Tel: 01903 737756
Email: planning@arun.gov.uk
www.arun.gov.uk/planning
Please ask for: Mrs D Johnson
Email: daun.johnson@arun.gov.uk
Telephone: 01903 737762
Our Ref: FP/55/26/PL
Your Ref:
Date: 13th May 2026

Application for Planning Permission

Development: Demolition of garage and conservatory, extension and alteration of existing bungalow to create two separate dwellings including a new crossover to public highway.

Location: 6 Ormesby Crescent Felpham PO22 8EN

Proposed Extension and New Dwelling
at 6 Ormesby Crescent, Felpham
for Mr J Bryant & Mr S Bryant
Drawing P01a June 2025 Scale 1:100 @ A3
Planning Drawing - Proposed Floor Plan & Elevations

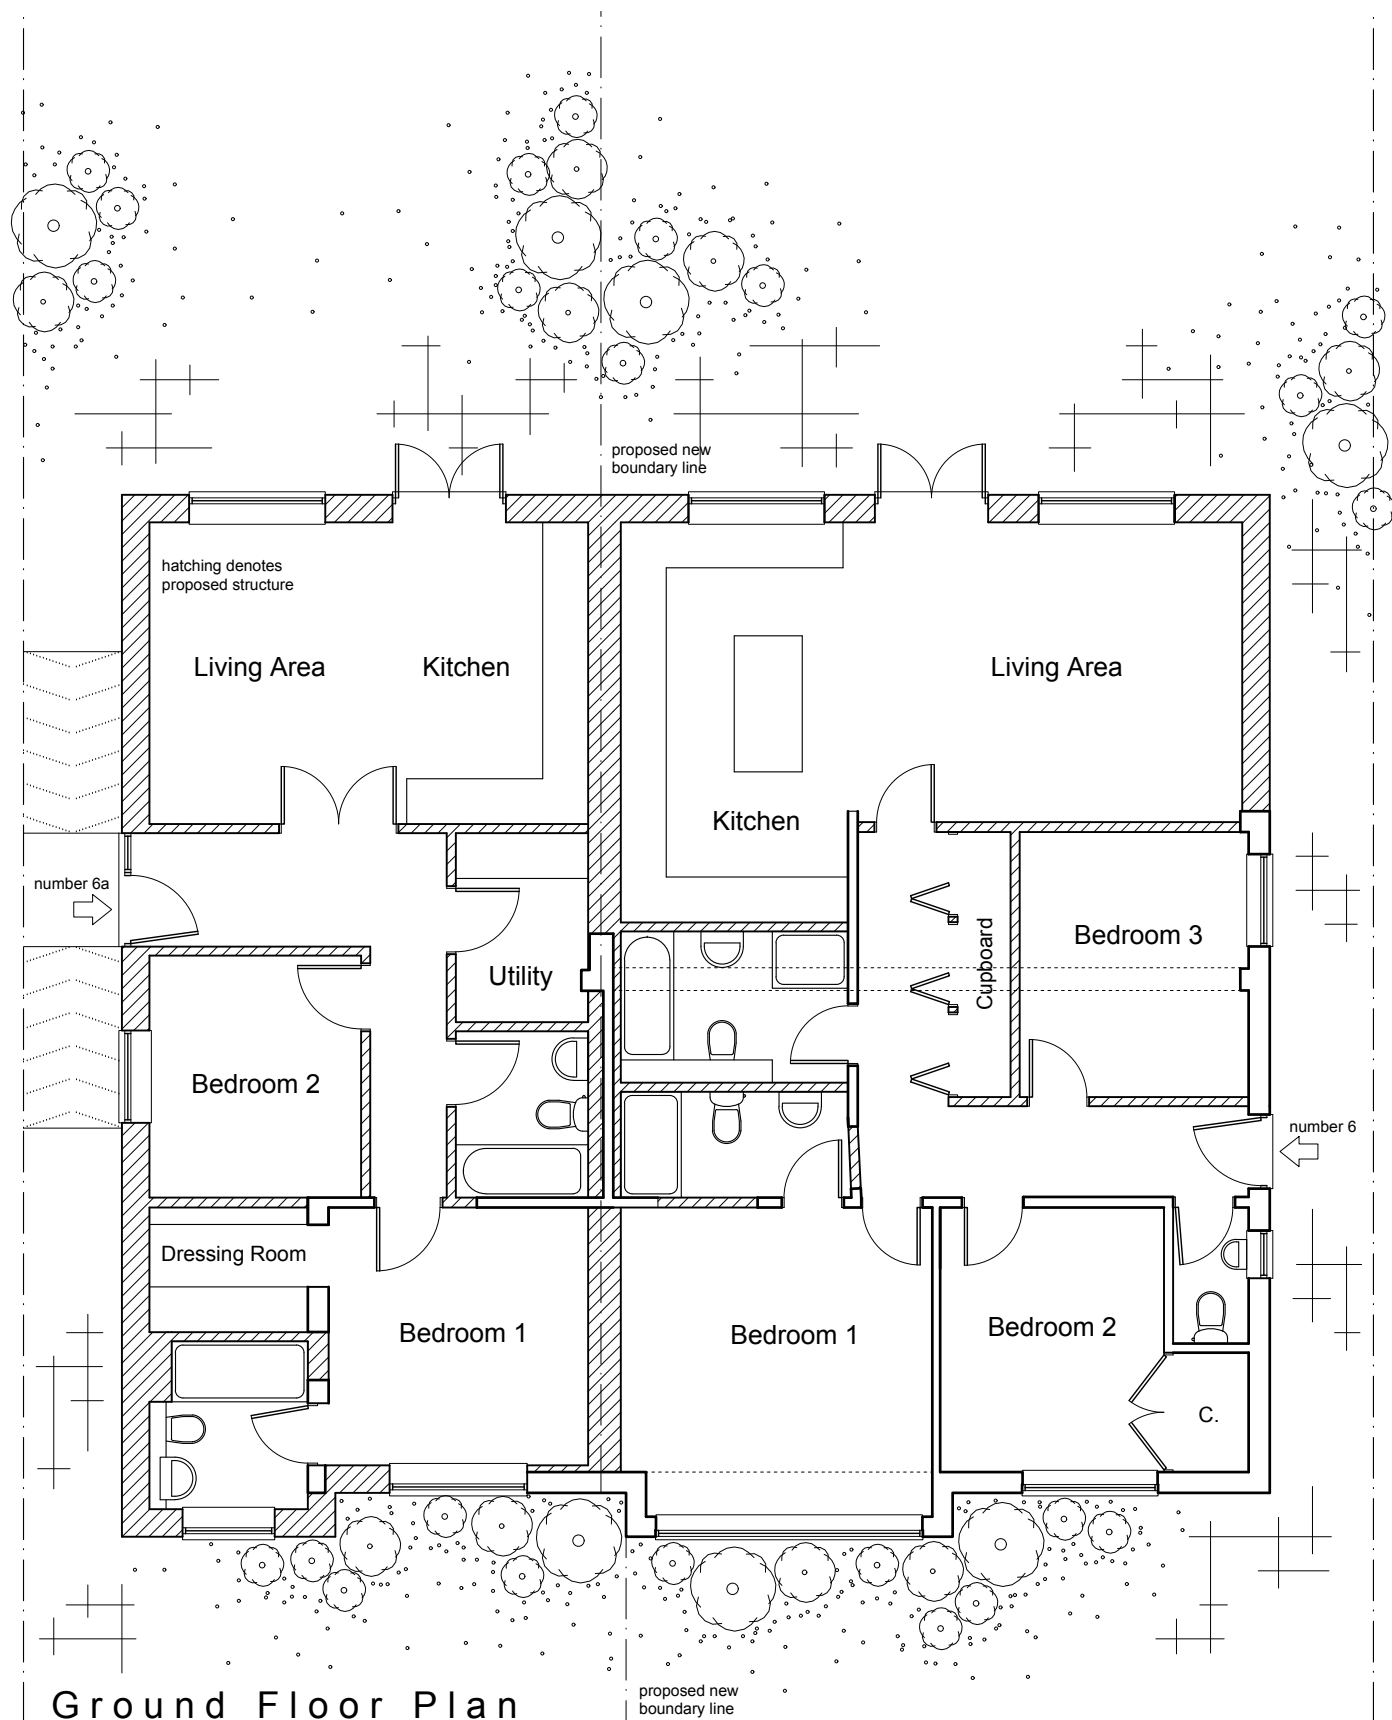
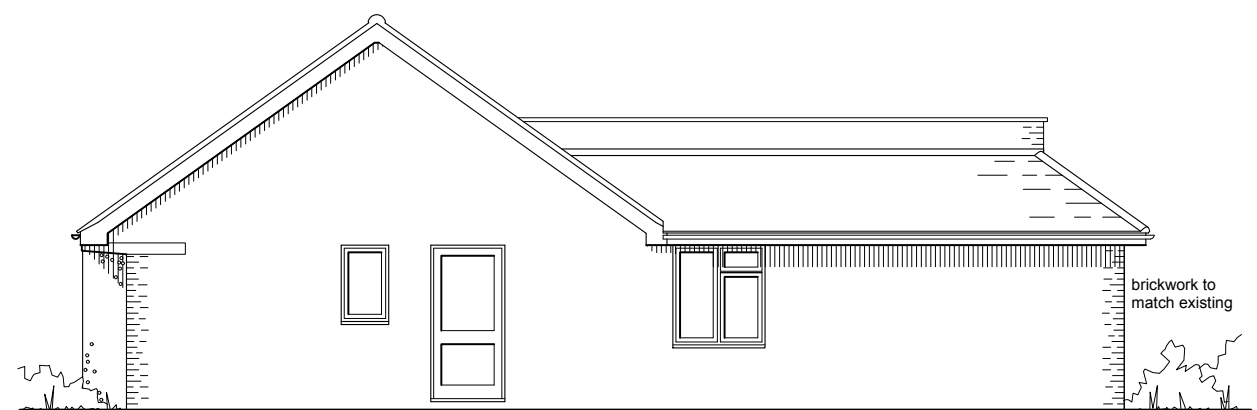
The proposed floor plan and south elevation do not accord. The WC window is in the incorrect position. Please amend accordingly.
